**Date: June 13, 2013**

**Project Name: Marriott Courtyard**

**Plan Reviewer: SFC Engineering Partnership, Inc.**

Plan Type: Construction Set - Architectural

3 THIRD FLOOR PLAN  
A0.2 1/16" = 1'-0"

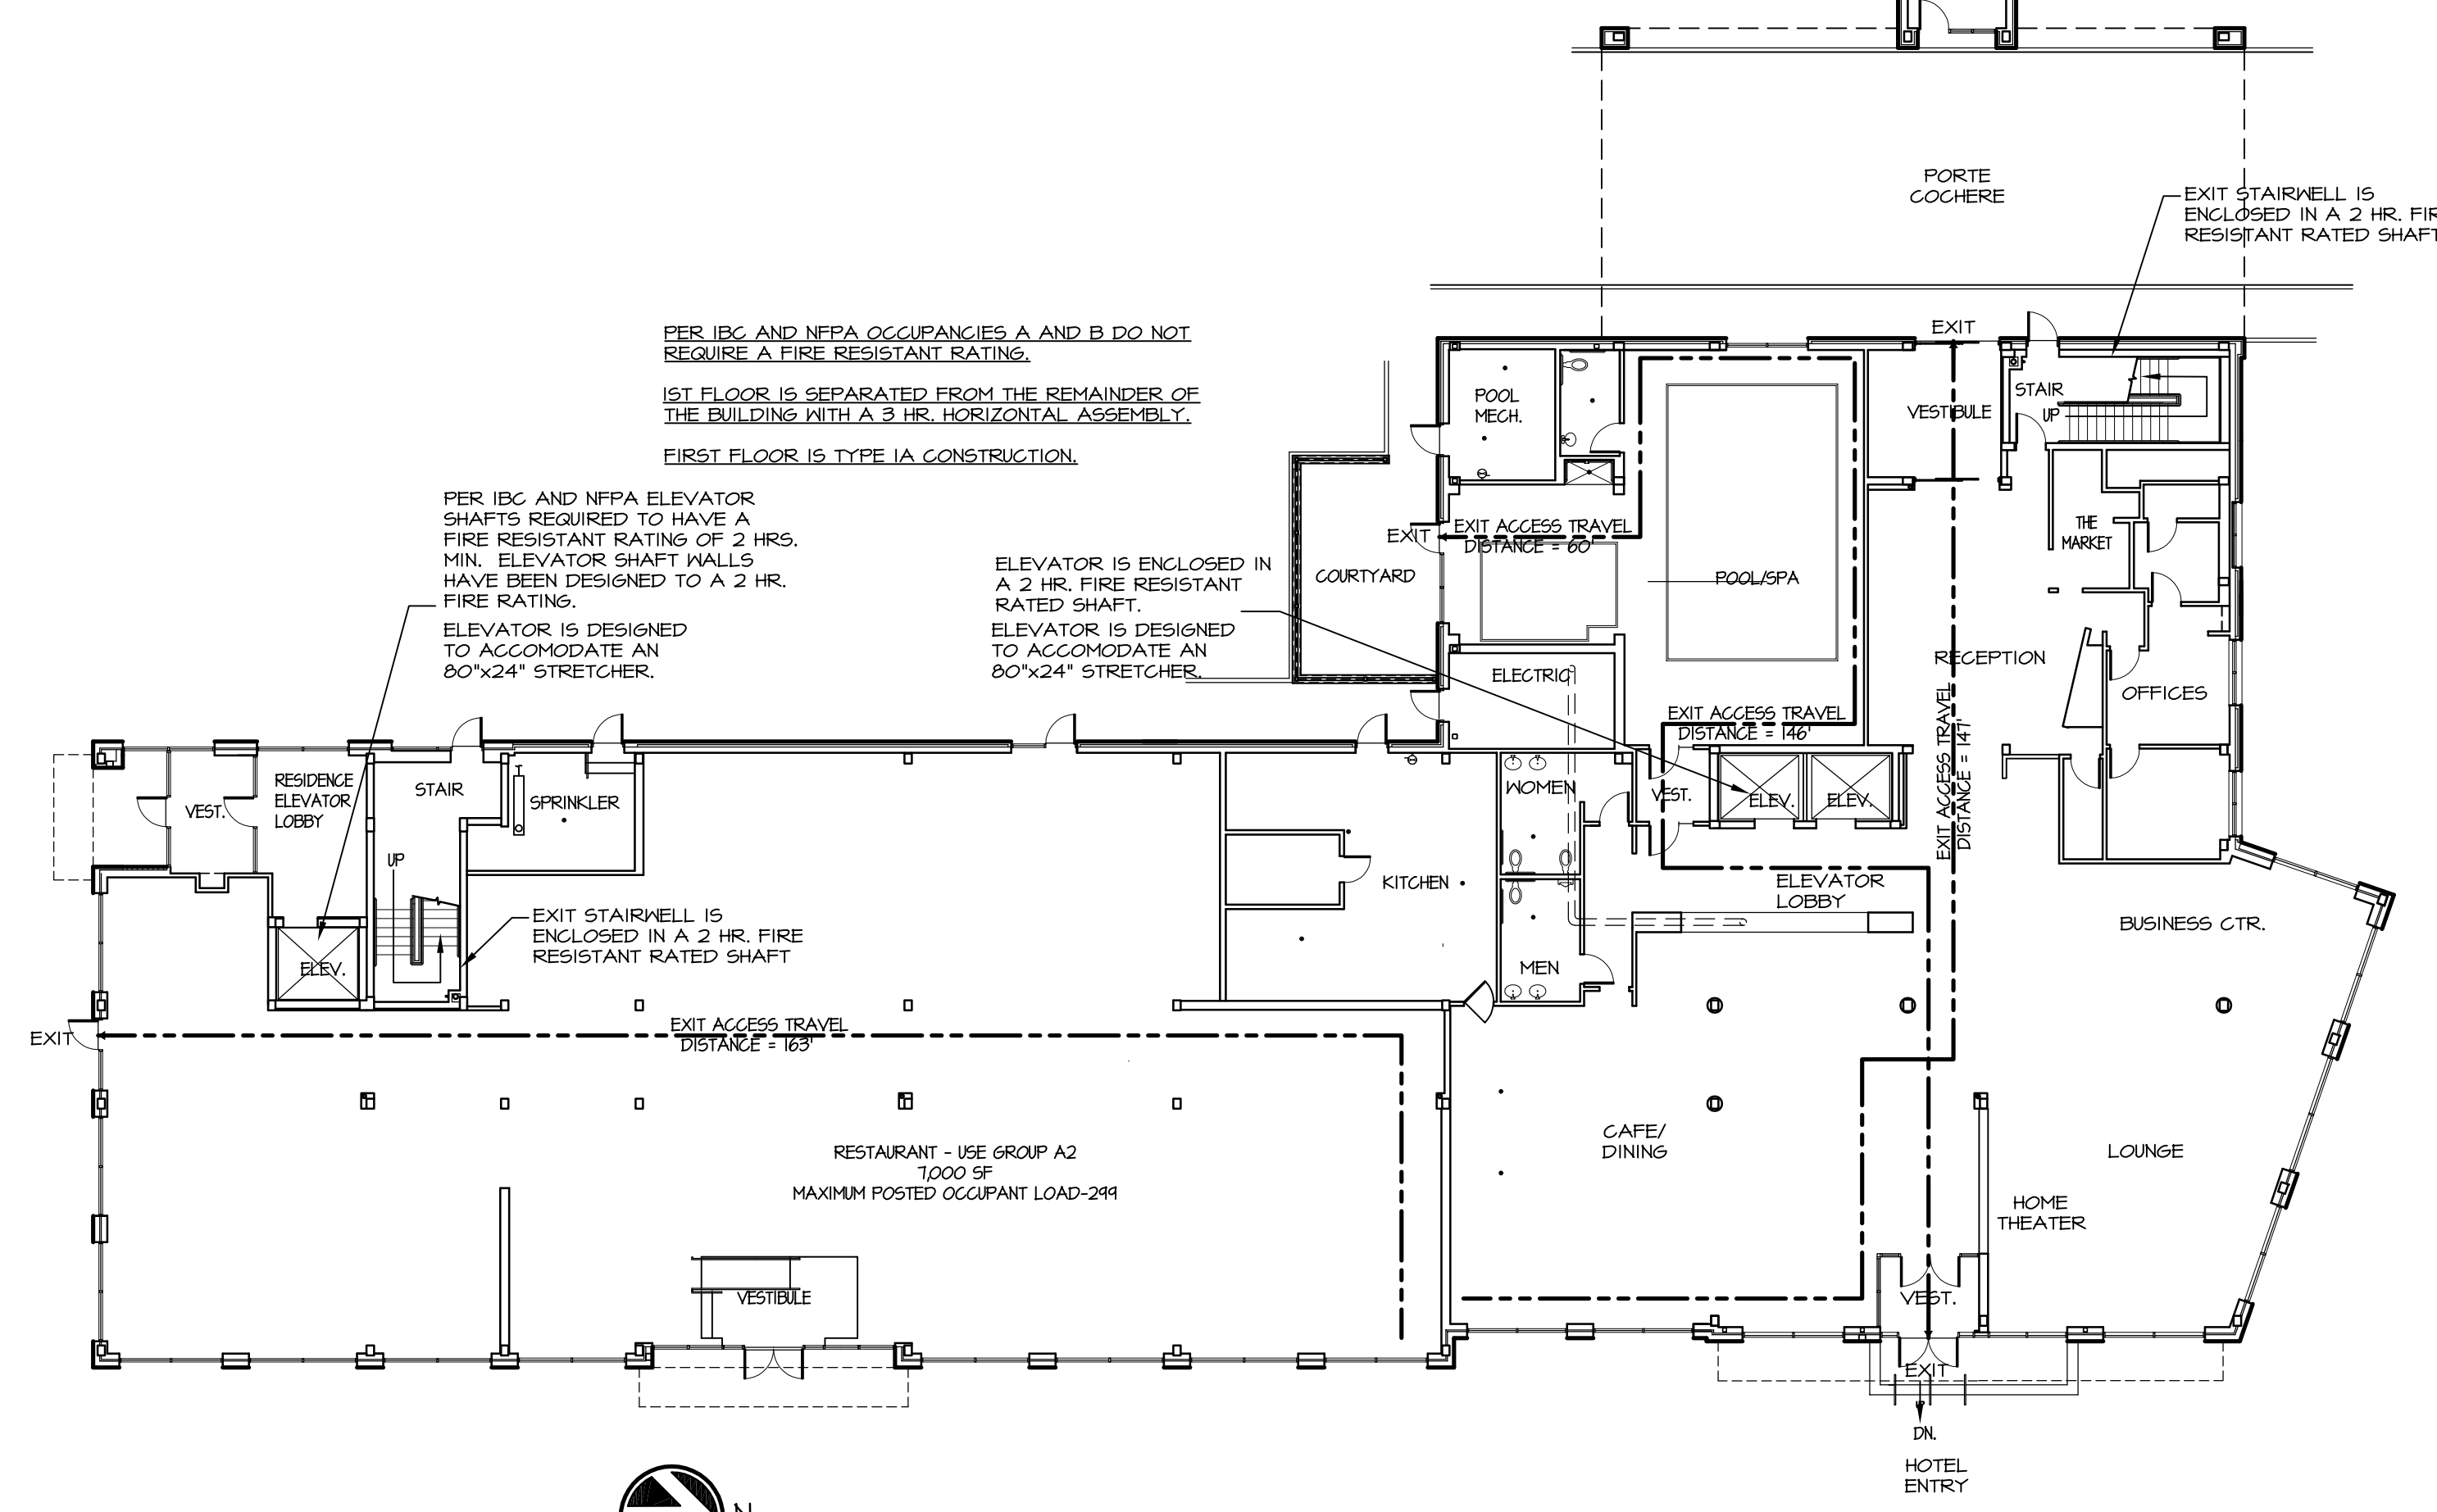
3. A0.2-3: Areas mixed with Assembly Use Groups cannot contain dead end distances in excess of 20'. At both ends of each corridor on floors 2 through 5, dead end distances exceed 20'.
